**East West Rail Network Phase 2 The Scheme  
Railway From London Road Bicester To Station  
Road Launton**

**20/03365/DISC**

**Proposal:** Discharge of condition 7 (a)(b)(ii) (landscaping proposals at Bridge 34A Station Road) of 18/01430/TWAO

Drawing Title  
**TWAO PLANNING  
CONDITION 7  
STATION ROAD (OXD/34A)  
VEGETATION REMOVAL DRAWING**

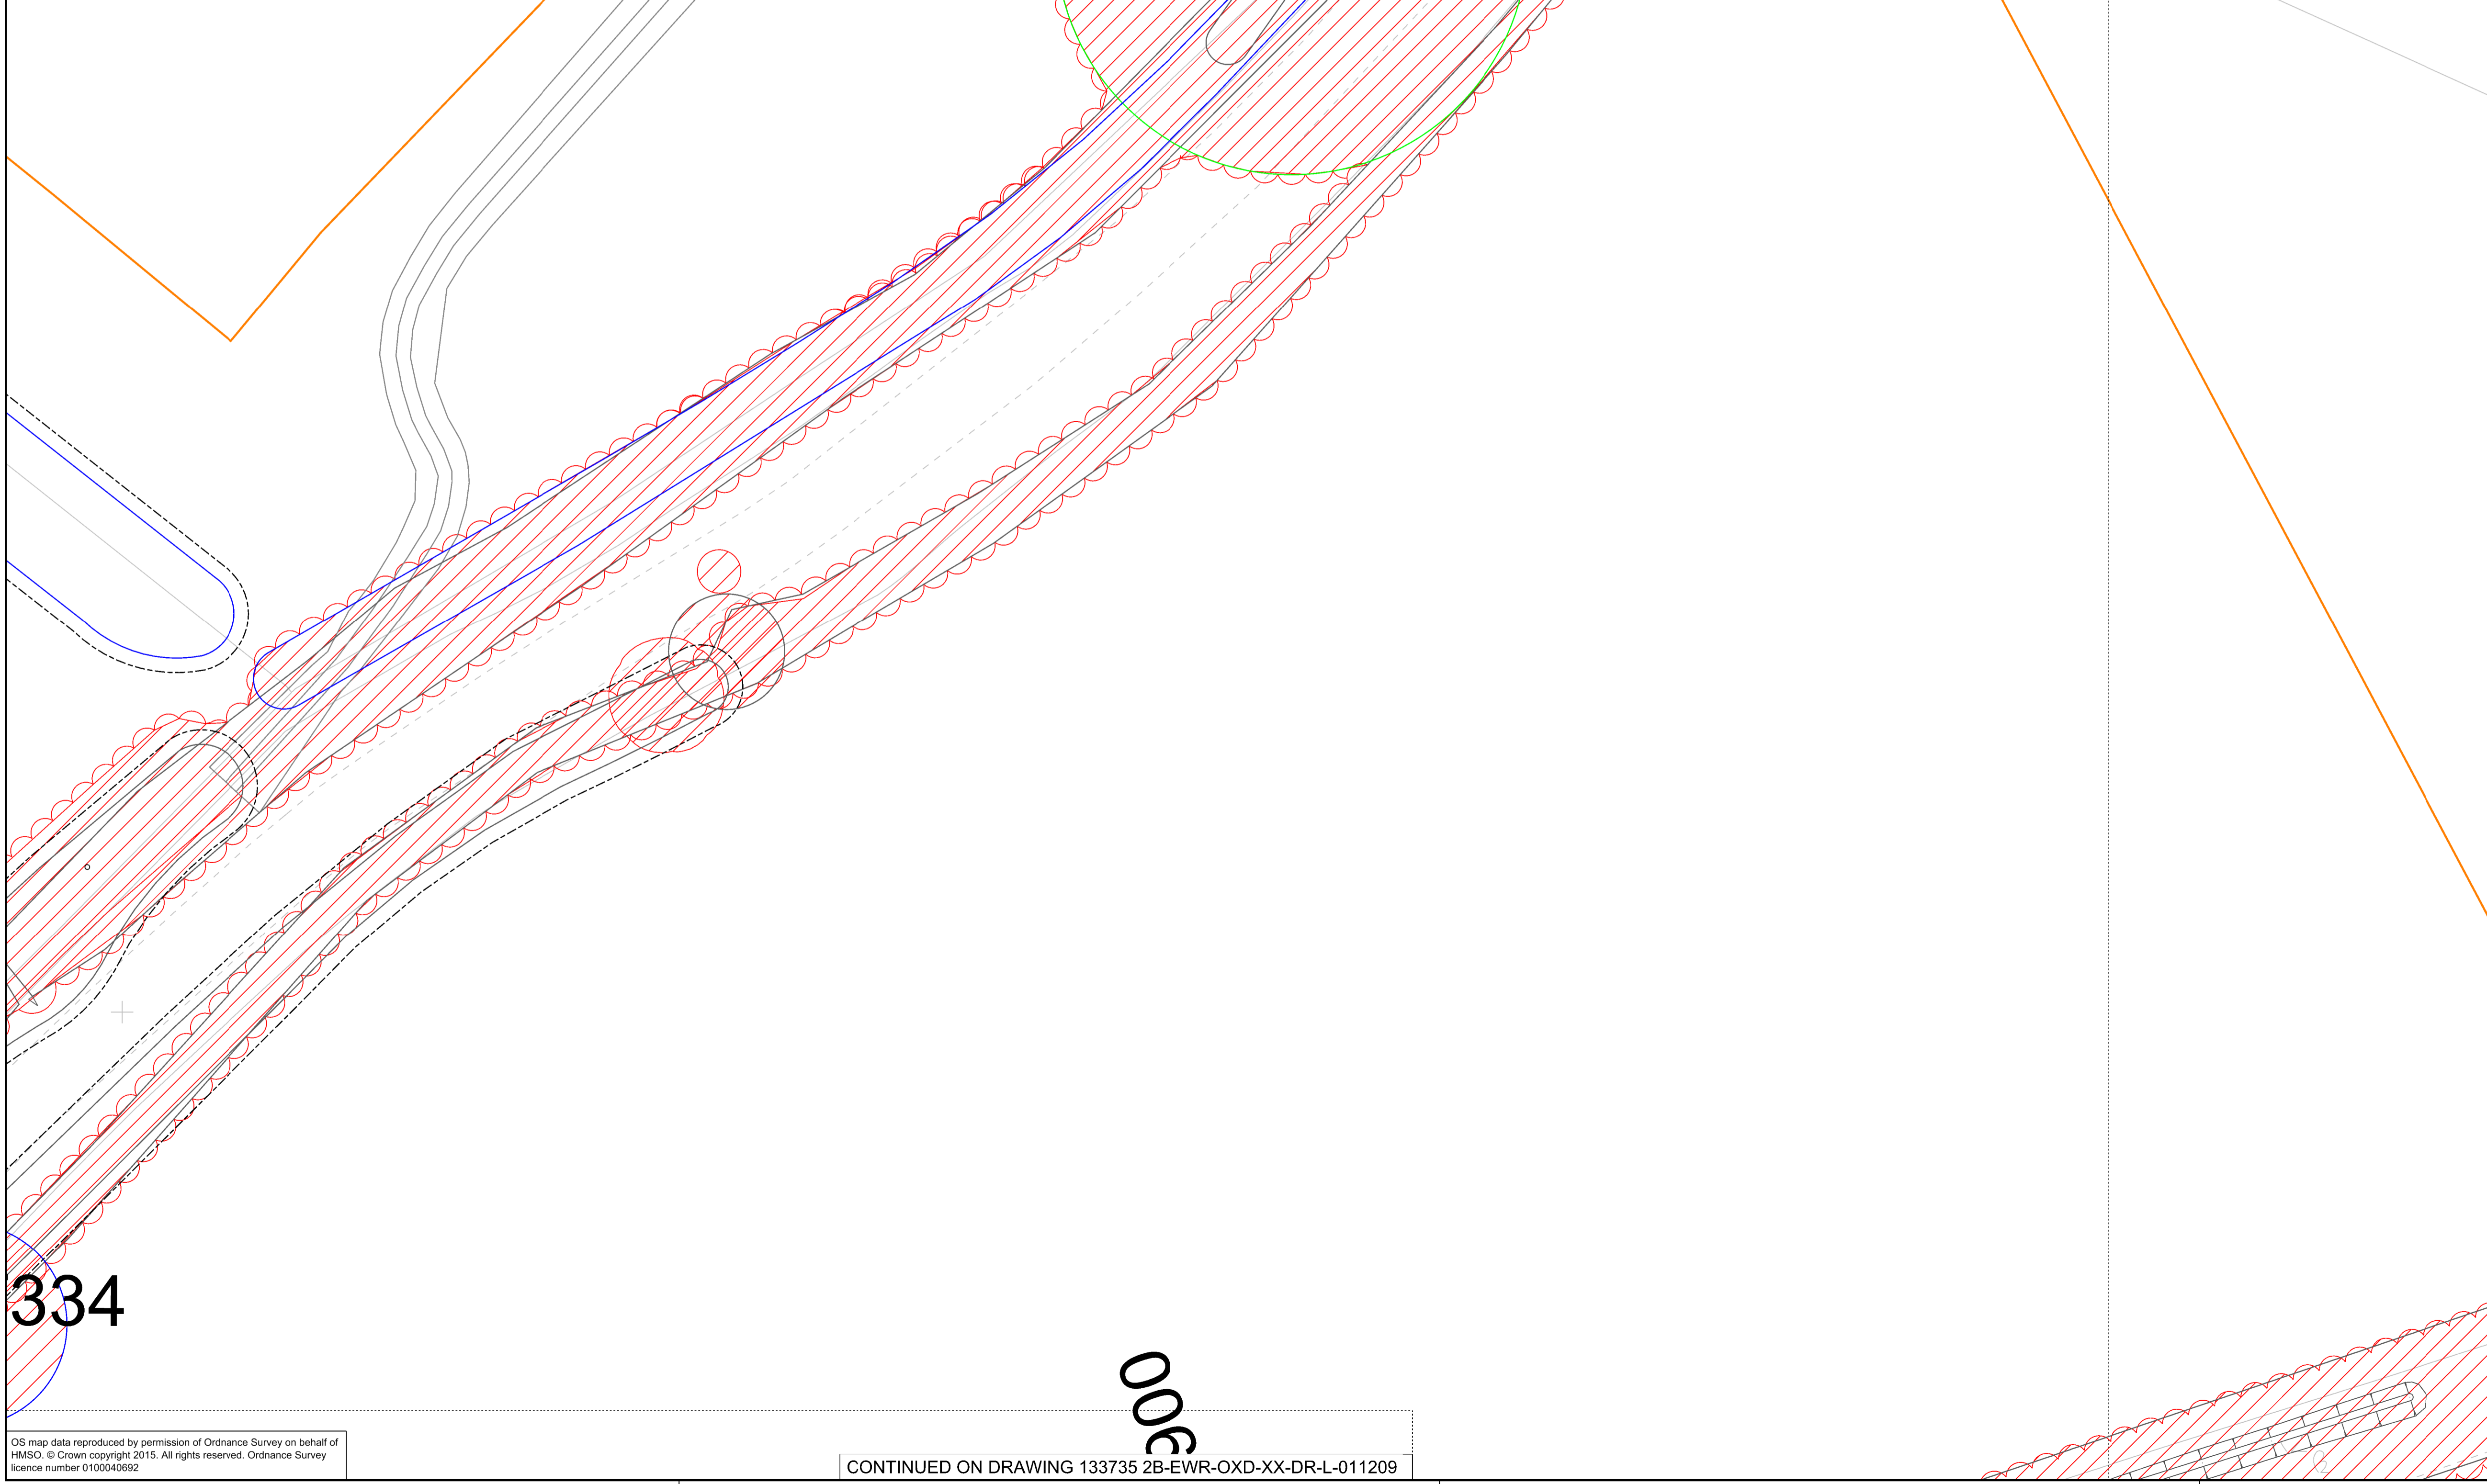
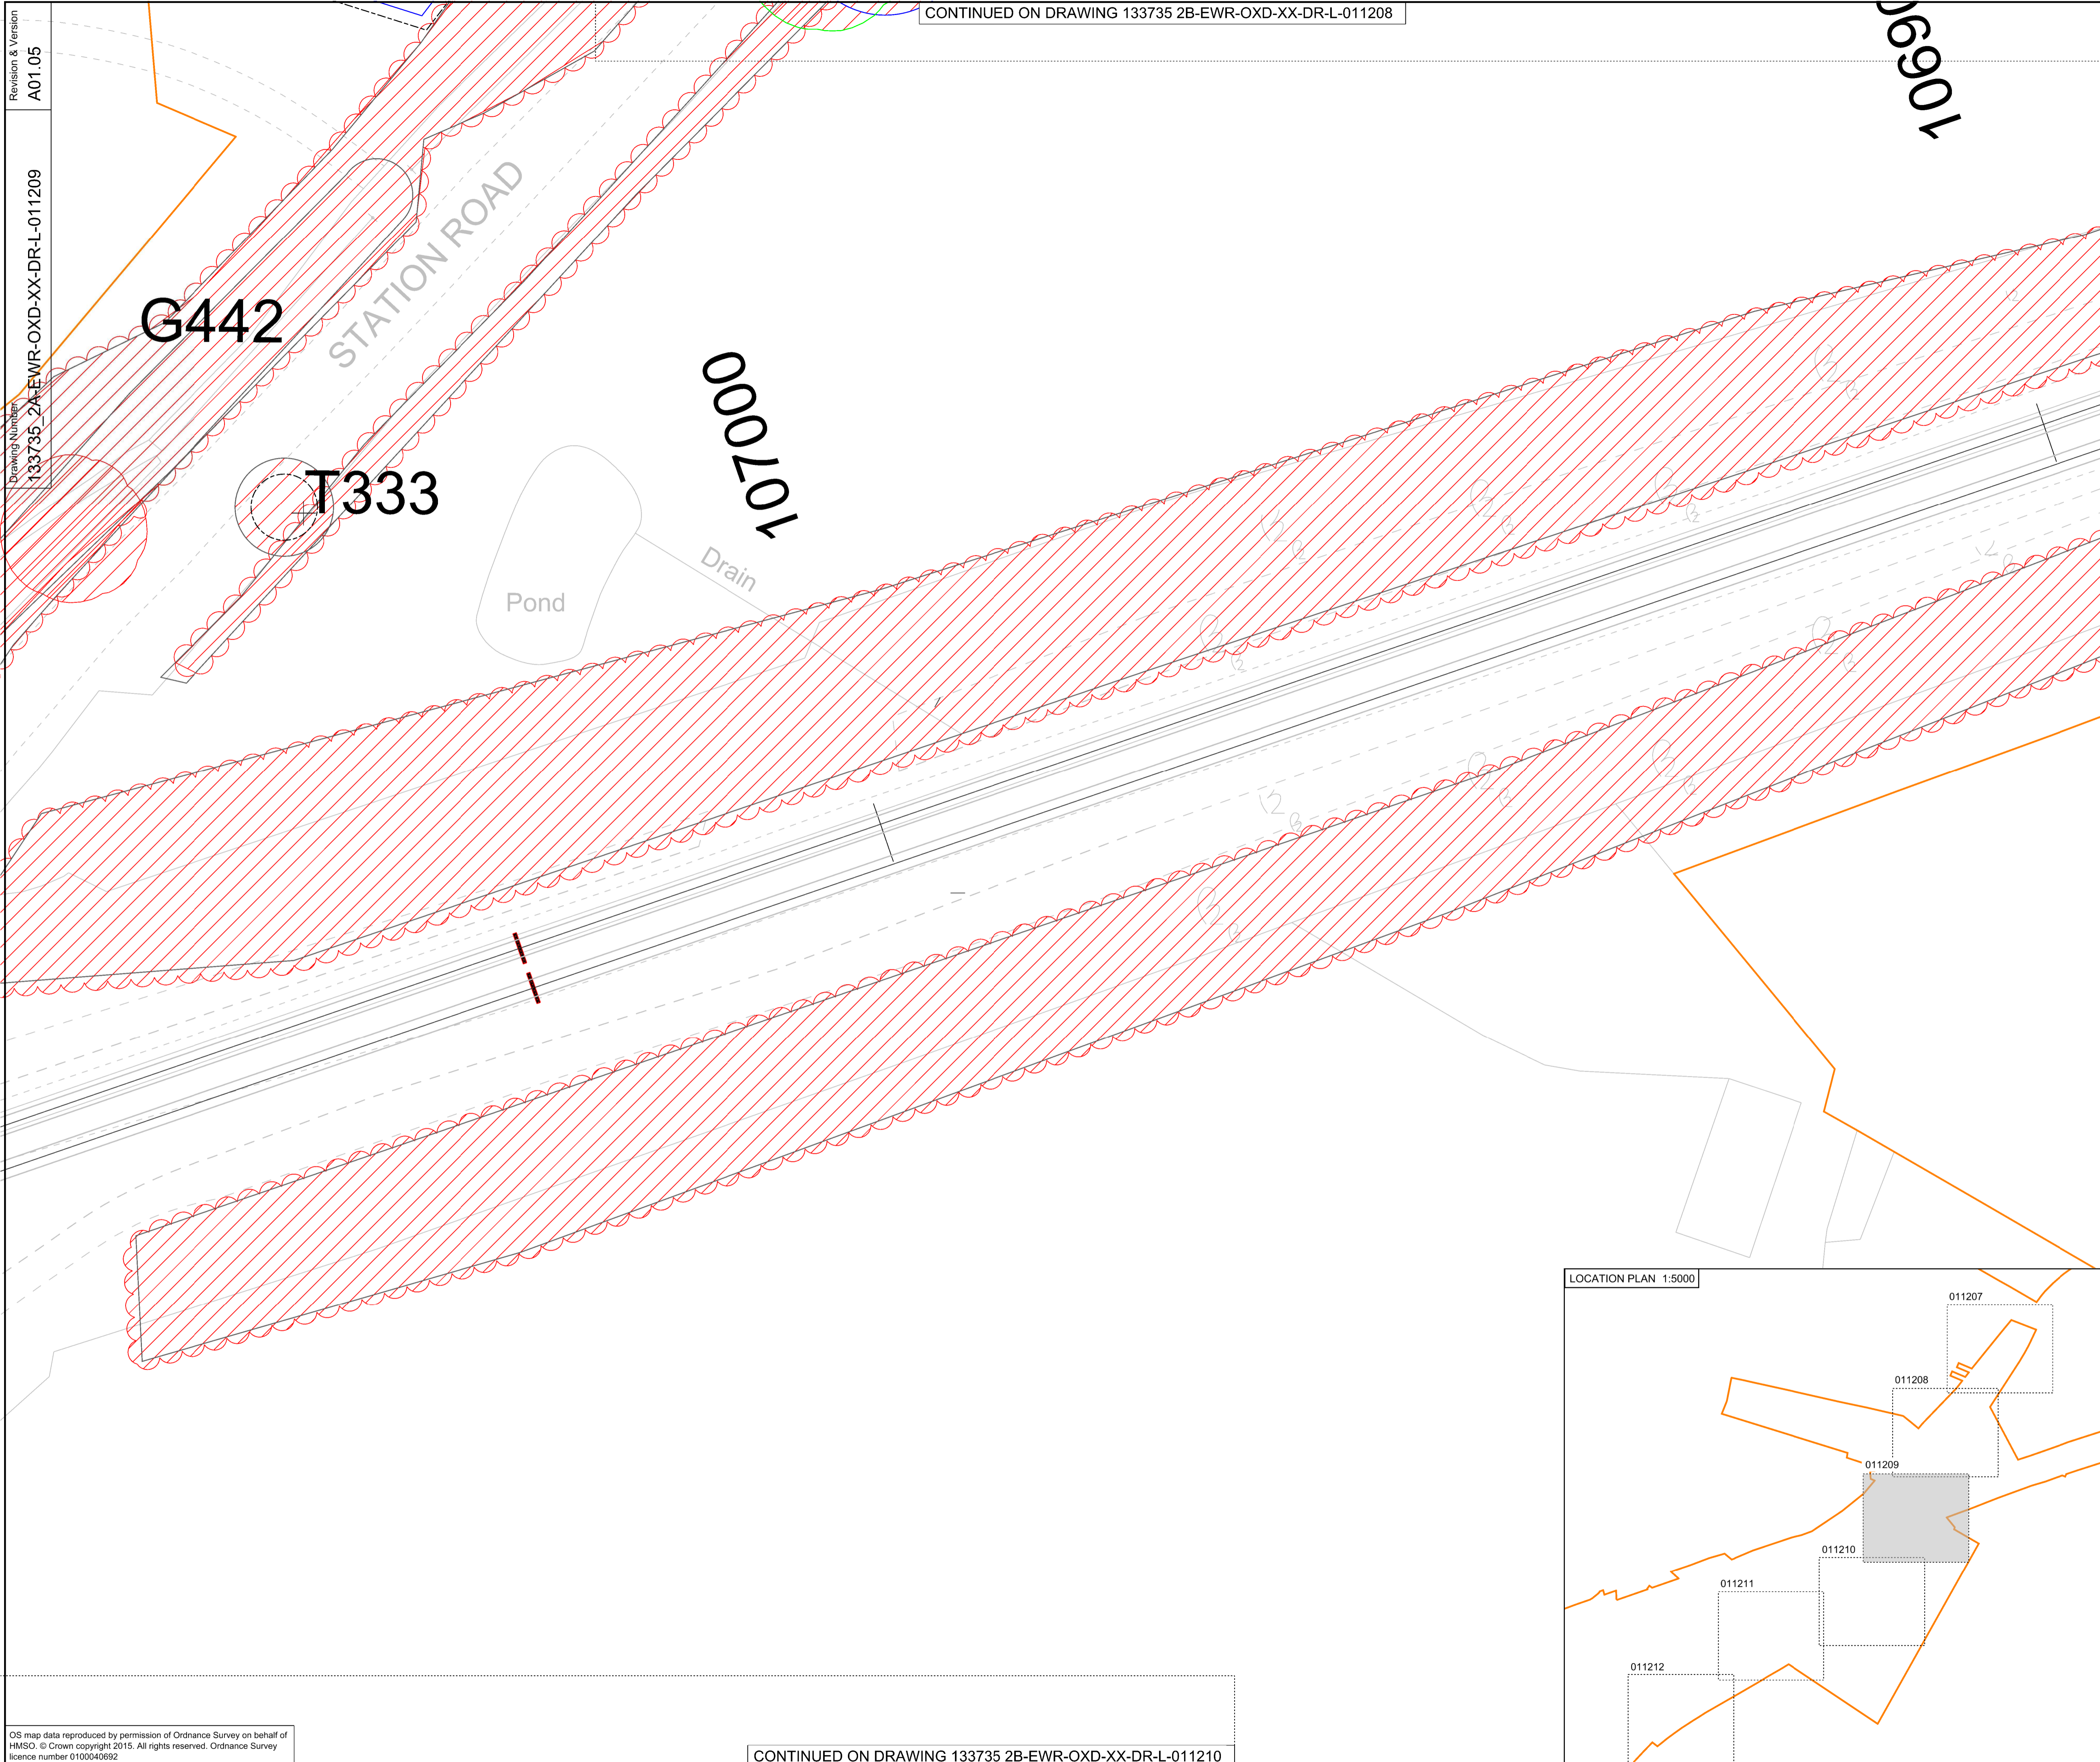
4.1 CDC Landscape Officer – I still have concerns about the extensive loss of established vegetation to facilitate this railway. Is there any compensatory measures included? How is the East West Rail Alliance going to improve the situation with additional native tree and shrub planting? The written specification appears to be fine.

5.1 The application has been assessed by the Council's Landscape Officer and his comments above were forwarded in December 2020 to the applicant for further consideration of the submission. A response from the applicant was received in March 2021 advising that compensation for the loss of vegetation would be provided along the whole of the network corridor and in addition ahead of the works, 19 ecological compensation sites have already been provided and in many cases are now becoming established.

- 5.2 Having regard to the above comments, it is considered on balance that whilst the loss of vegetation at this particular area is regrettable, that overall, the scheme delivers adequate compensation planting and landscaping elsewhere. The application is therefore recommended for discharge accordingly.
- 5.3 The original application was EIA development. The application submission seeks to deliver the landscaping scheme as set out in the original submission and has no additional impacts above those already considered in the original ES. Therefore, the EIA is considered sufficient for the purpose of considering the information provided for this condition and it has been taken into account in considering this subsequent application.
